DOC19/957681

**State Significant Development for proposed plant 2 upgrade works – Lot 7 DP1059698 –  
780 Wallgrove Road, Horsley Park – SSD 9601**

## Attachment A

**Figure 13:** Comparison of Observed Horsley Park BoM AWS (Left) vs CALMET Predicted (Right) Wind Data – 2017

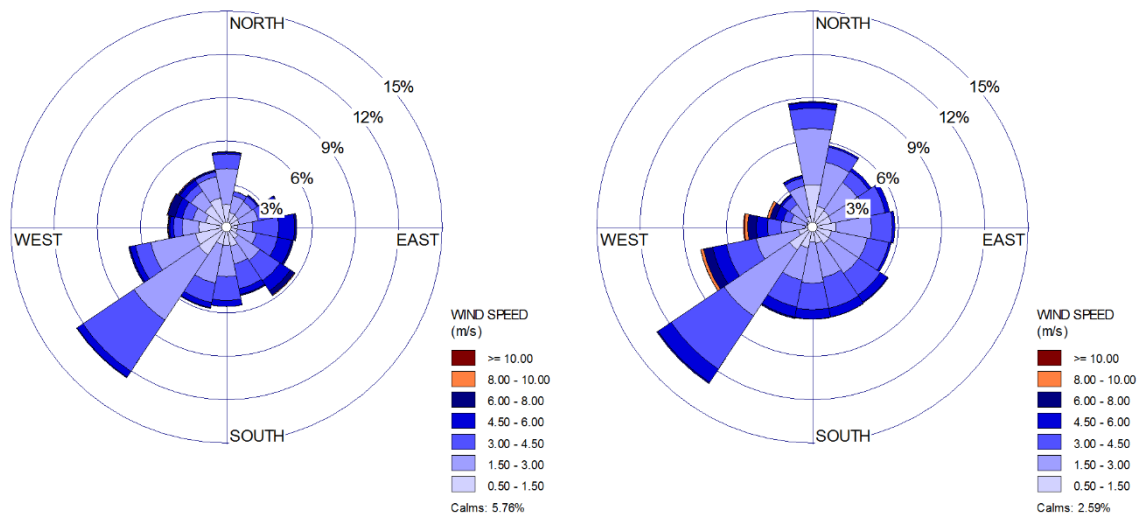
The EPA advises that there are significant differences between the observed (BoM) meteorological data and the modelled (CALMET) meteorological data (Figure 13 of the AQIA).

The EPA advises that the presentation of CALMET generated long-term meteorological data only does not adequately establish that this data describes the expected meteorological conditions at the site.

The EPA **recommends** additional information be provided on long-term site-representative meteorological data collected from a monitoring station and a detailed discussion on the prevailing meteorological conditions at the site including an analysis of wind speed and direction, stability class, ambient temperature and mixing height.

The EPA **recommends** an adequate justification of the use of 2017 for dispersion modelling compared to the long-term site-representative meteorological data collected from a monitoring station be provided.
